28 May 2021

2021/91239/FU – Redevelopment of 410 & 412 Birkby Road, Huddersfield, HD2 2DN

drawing
Survey (Existing Dwelling B):
410 Birkby Road: Elevations

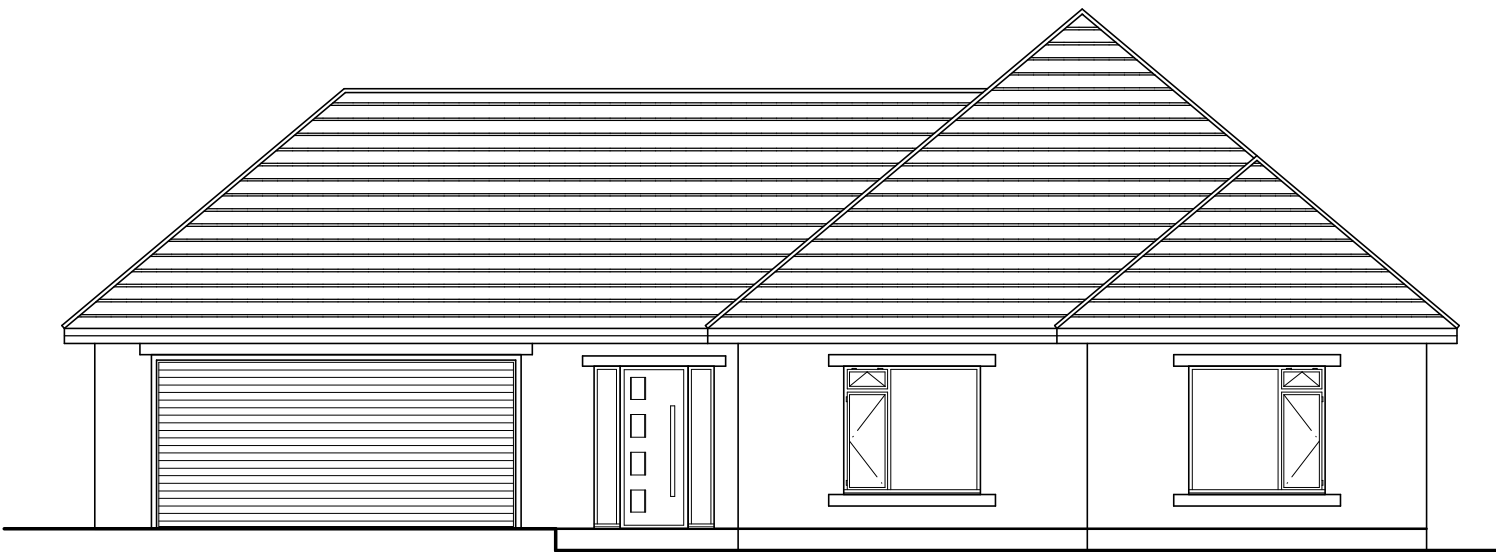
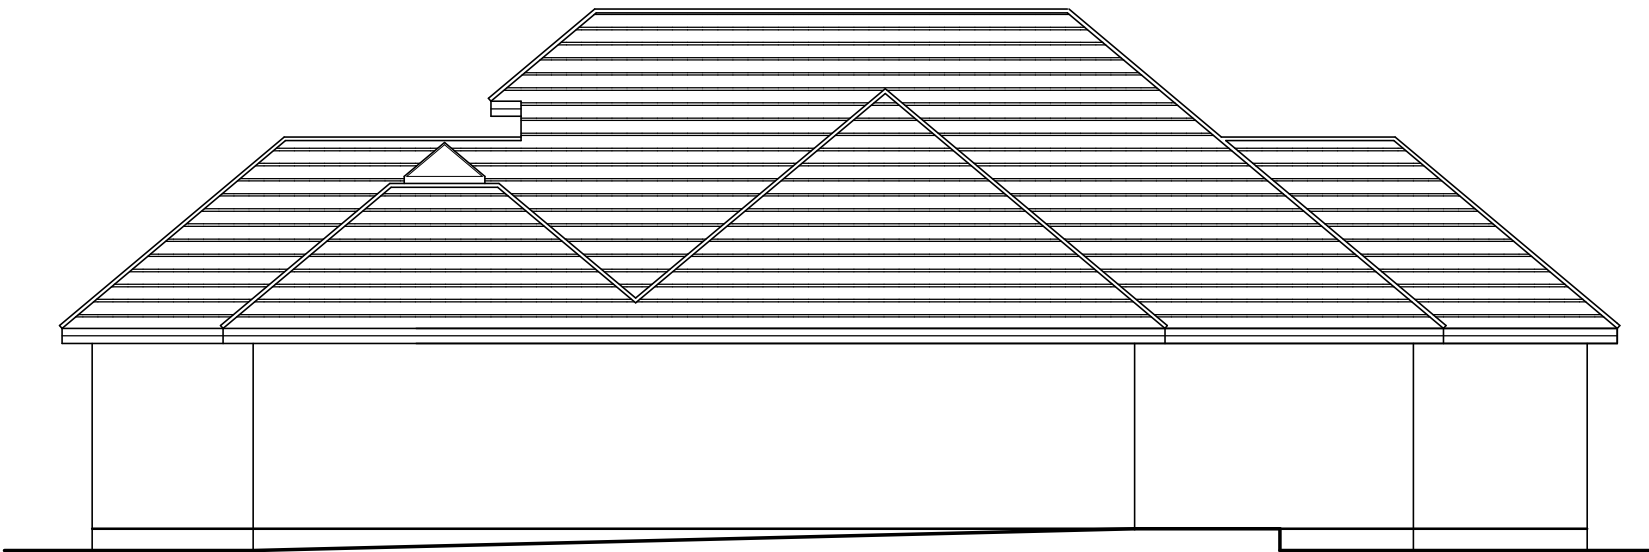
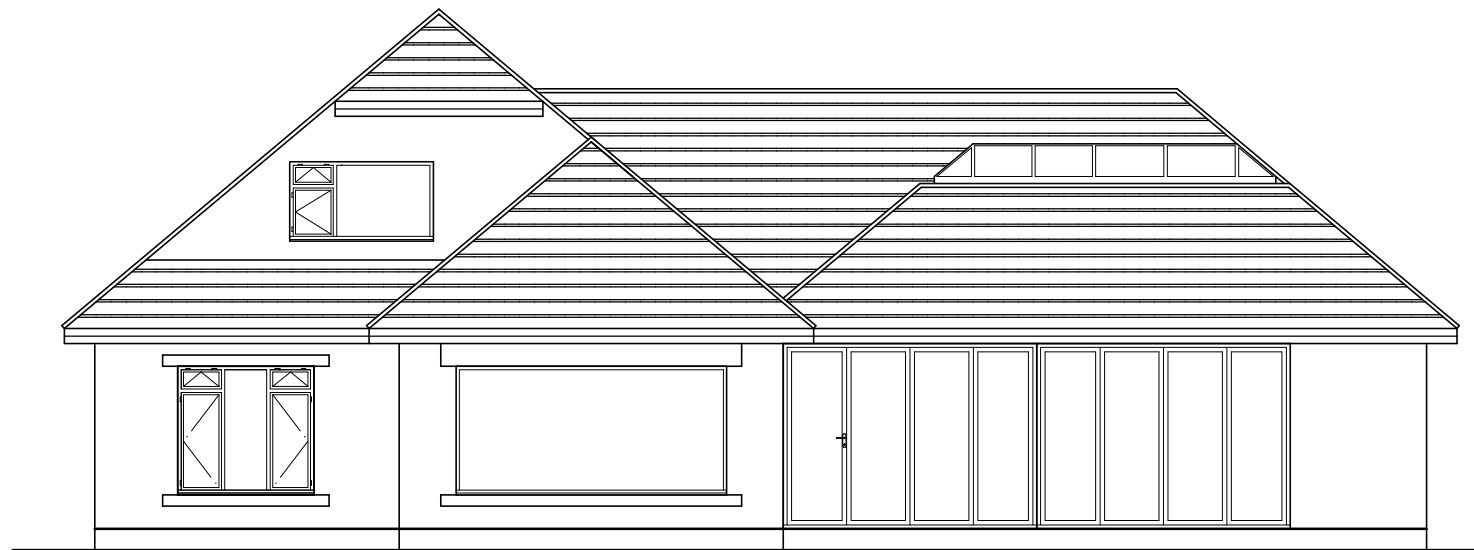
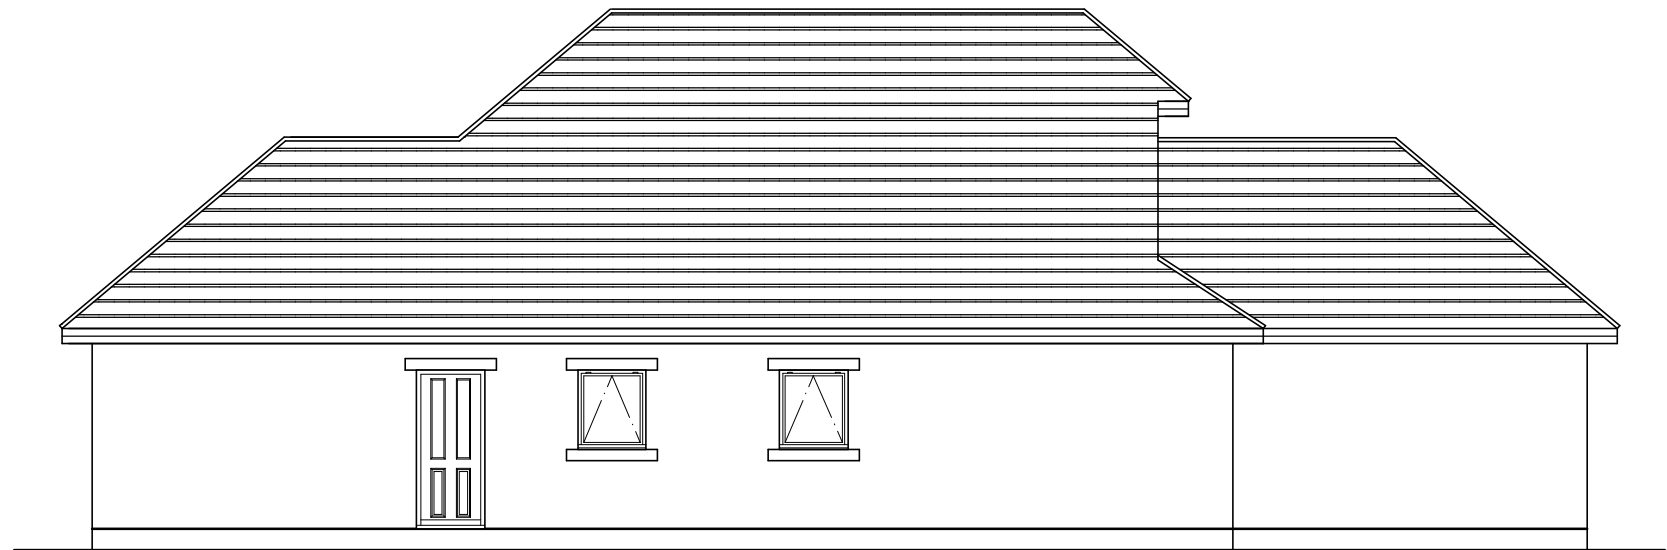
Plan Ref 21.21.03 Existing Dwelling B (bottom right) demonstrates the existing eastern elevation and comprises a single storey with tall roof, albeit parts of the elevation step in and the roof plane is sloping away from the boundary. It is a largely blank elevation other than an access door and two obscure glazed windows which the accompanying floorplan (Plan. Ref. No 21.21.02) suggests are for the utility and two bathrooms. Condition 4 attached to permission 2013/90345 is relevant in this case.

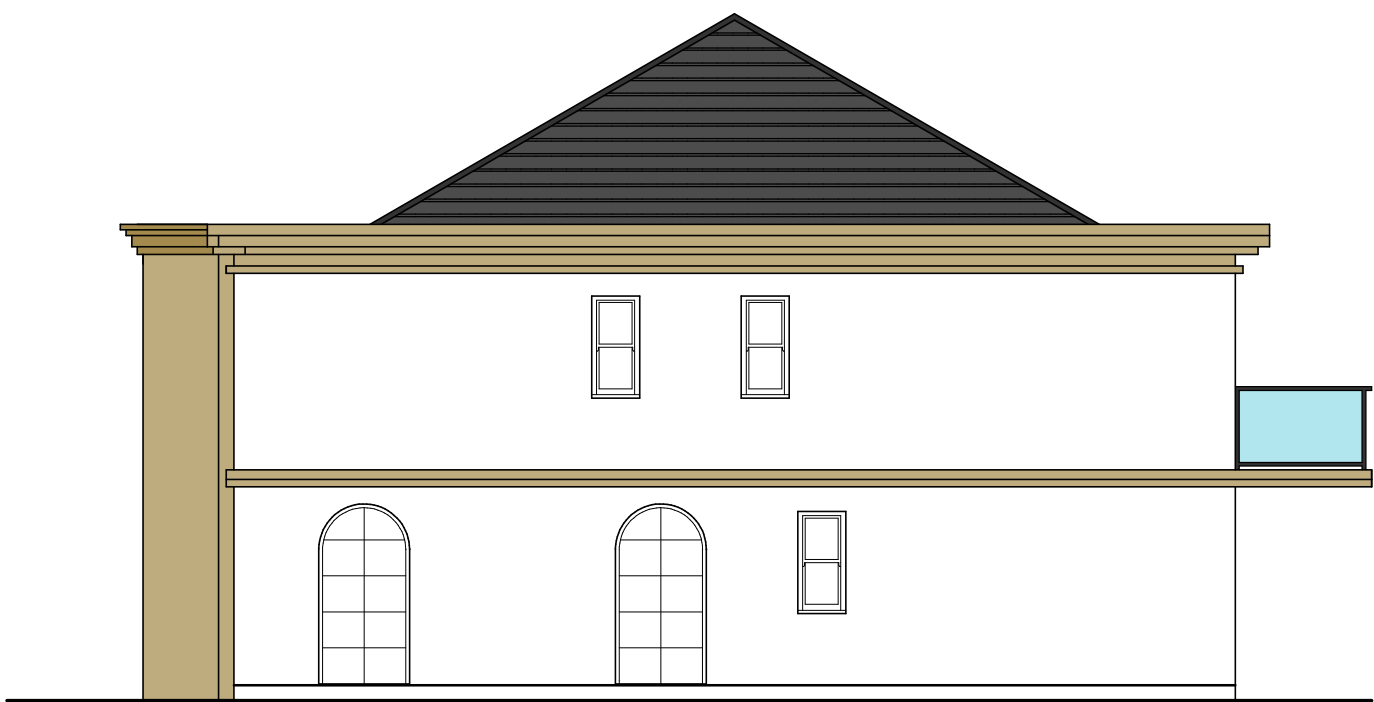
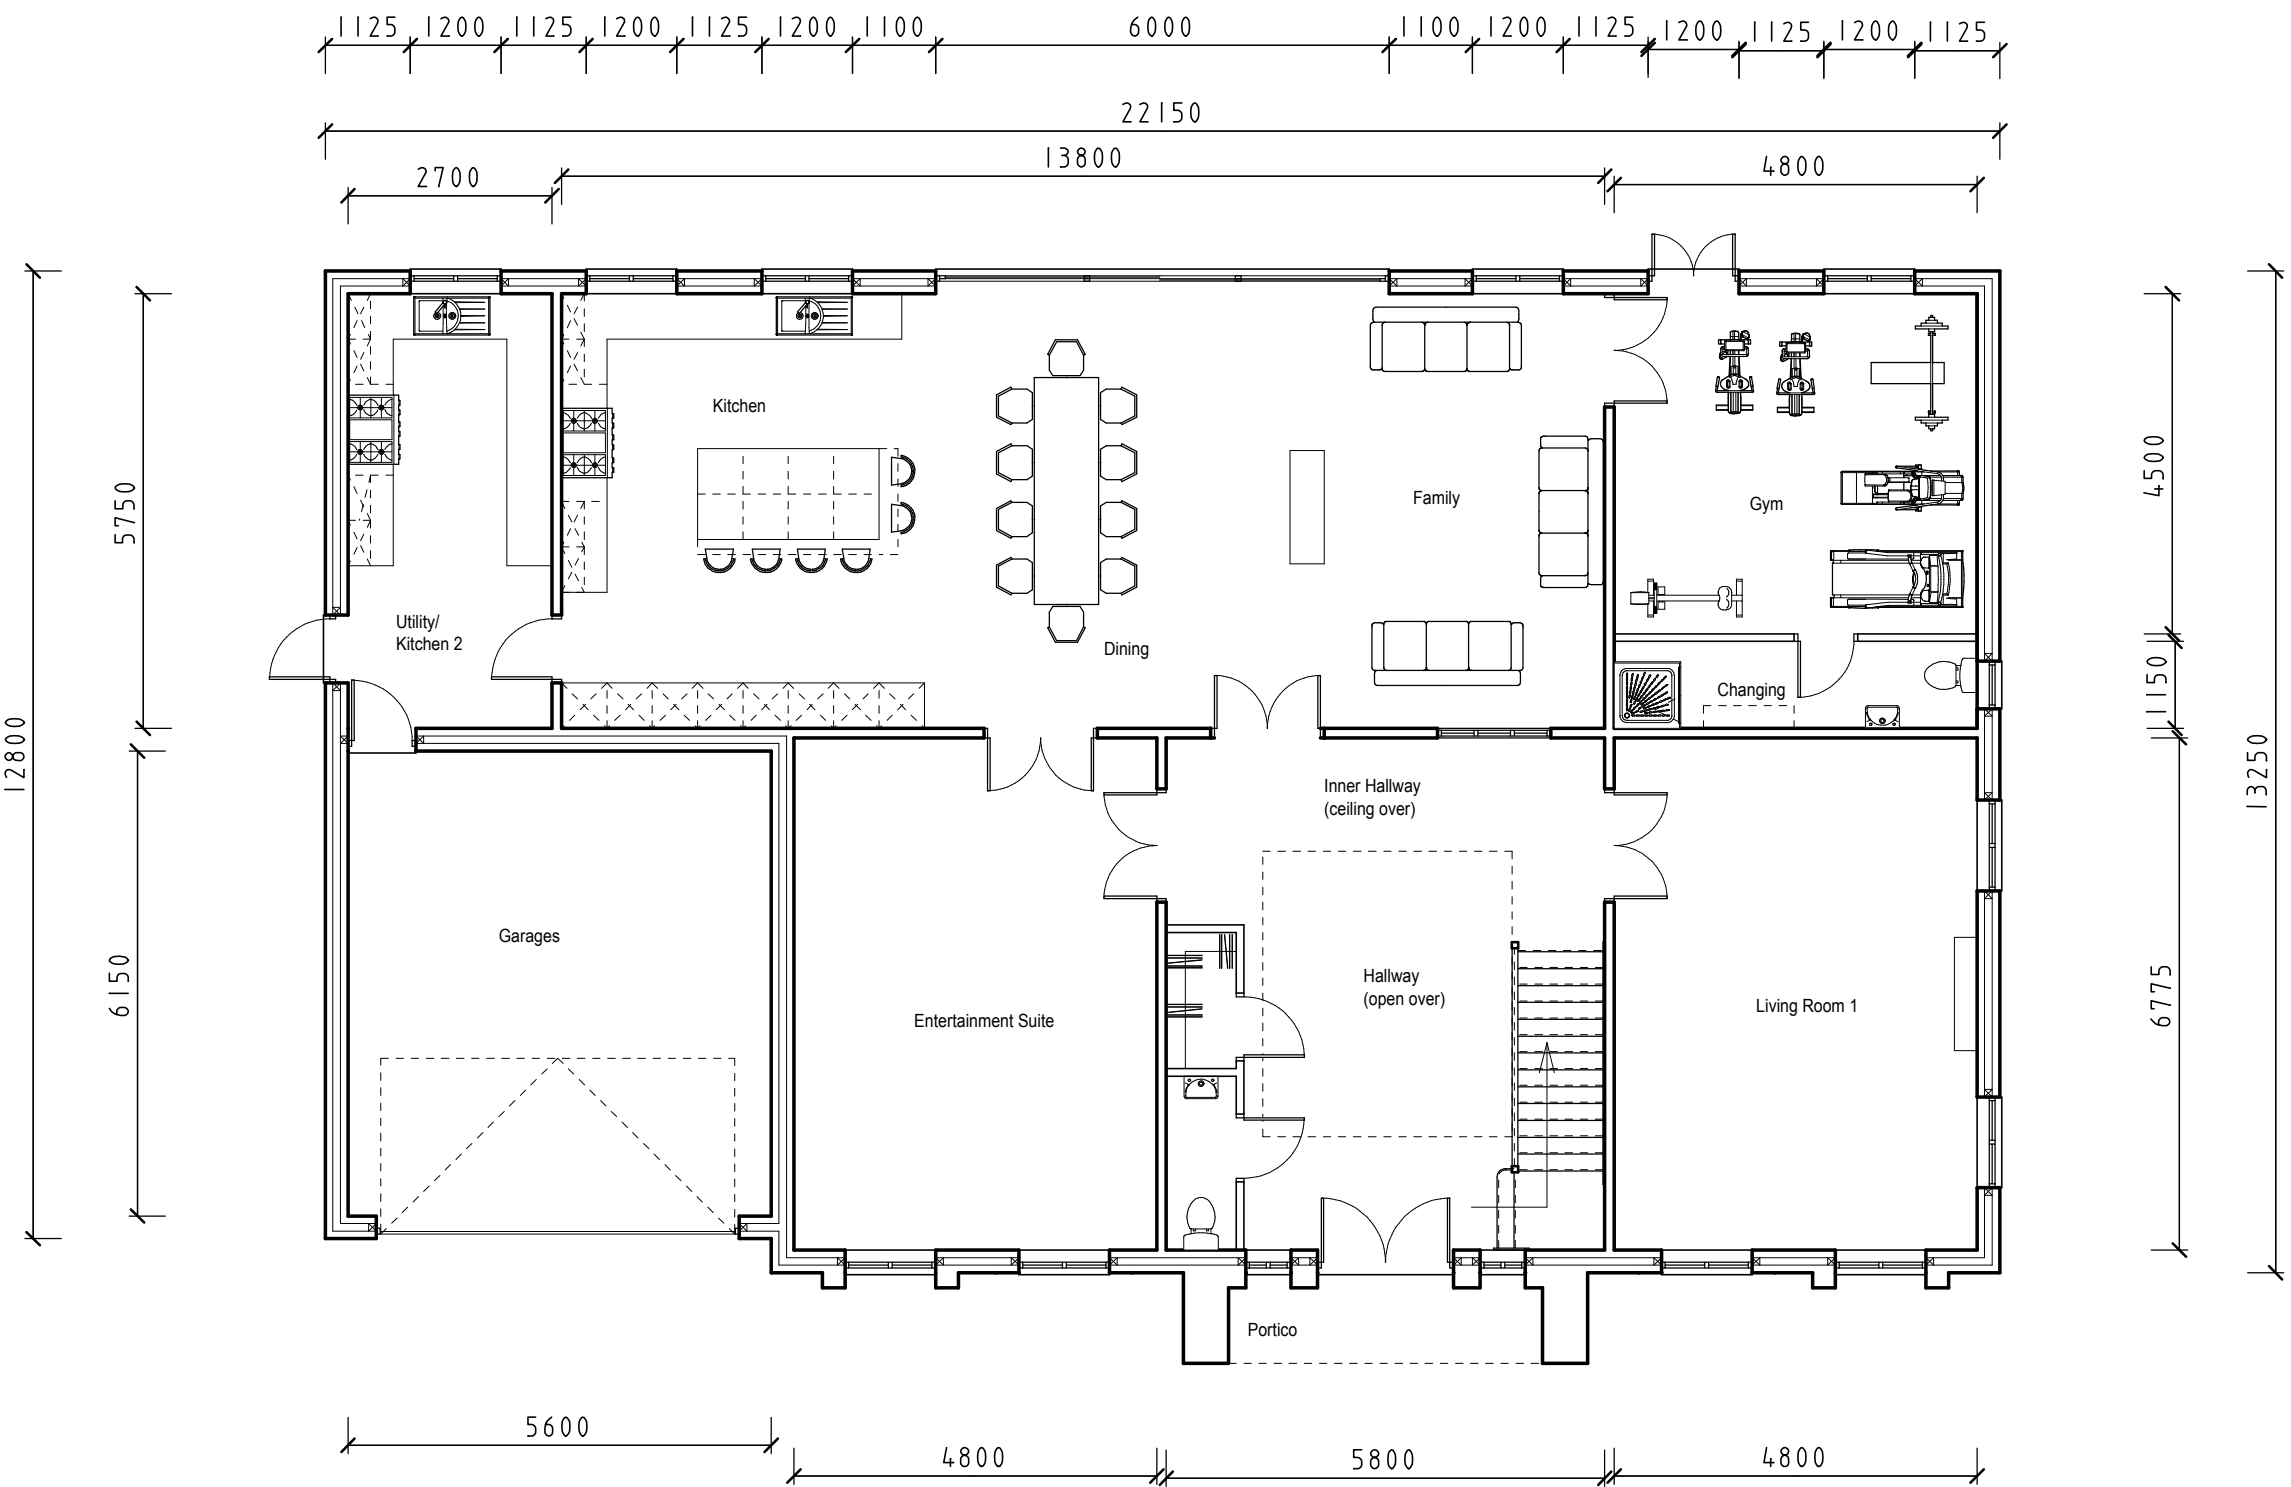
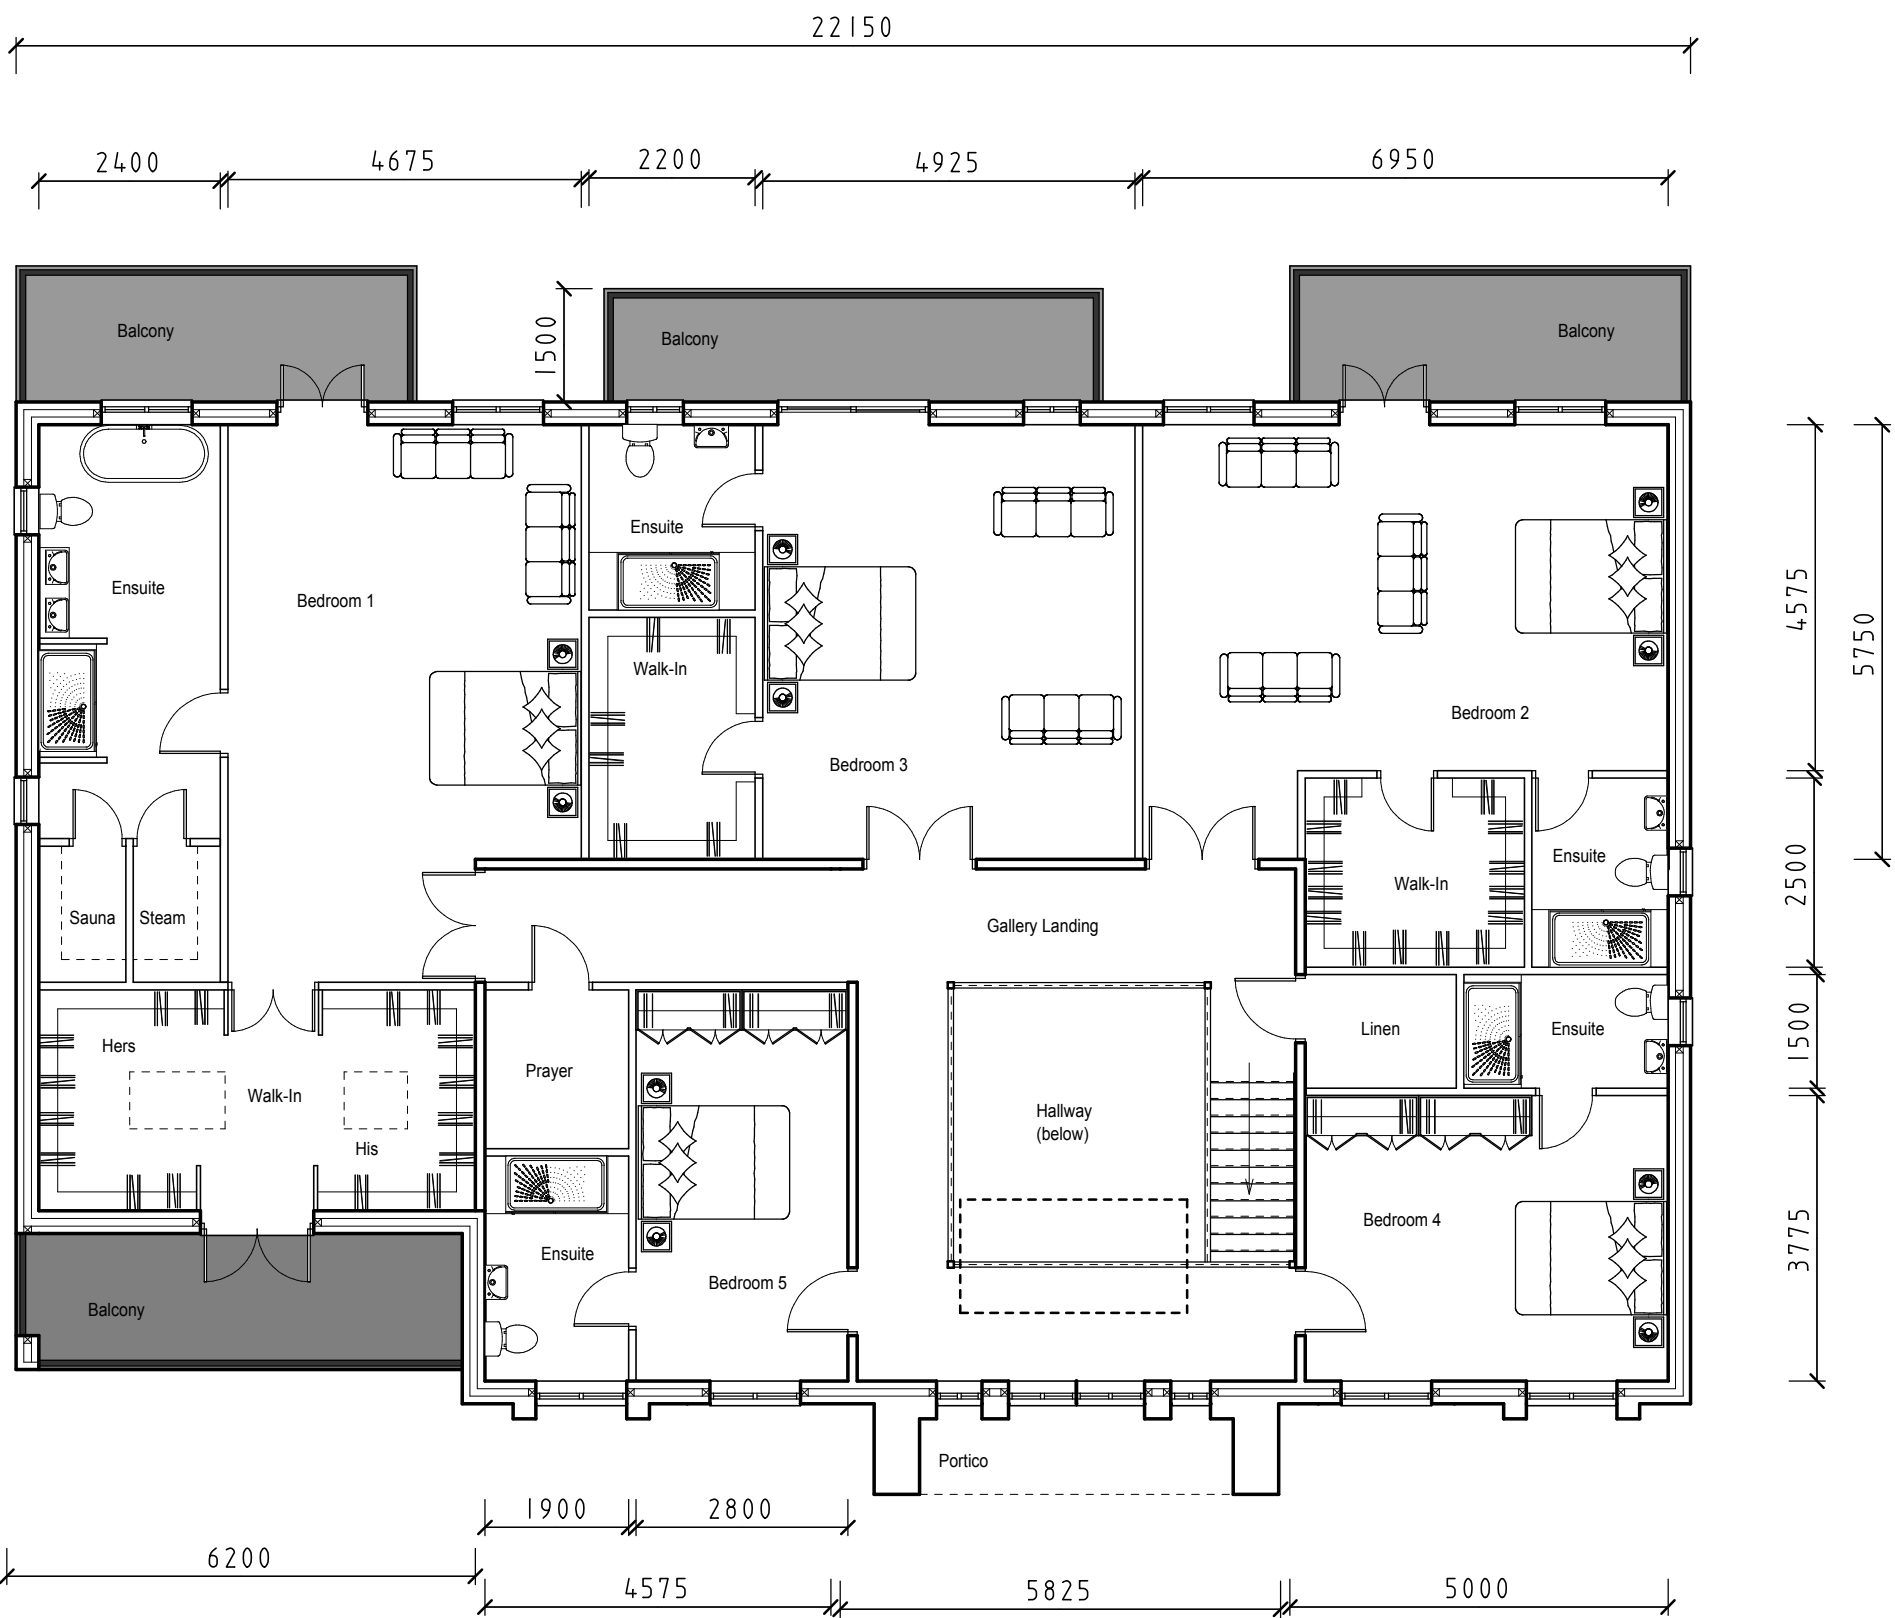
Turning to the detailed drawing for the new dwelling B (Plan Ref. 21.21.11A) this suggests that the two-storey elevation will contain three floor-to-ceiling windows to the ground floor and three smaller windows at ground and first floor). The accompanying floorplan indicates two of the larger windows serve the living room whilst the third is for a gym. The smaller windows are for a changing room and two en-suite bathrooms (at first floor). At first floor level the plan and elevation indicate a glazed cantilevered balcony to the north elevation corner (i.e. that part of the dwelling closest to No. 9 Valley Head). When the patio area (between the new dwelling and retaining wall is considered this will represent a substantial breach of privacy, with direct overlooking of the garden and some of the principal rooms to No 9 Valley Head.
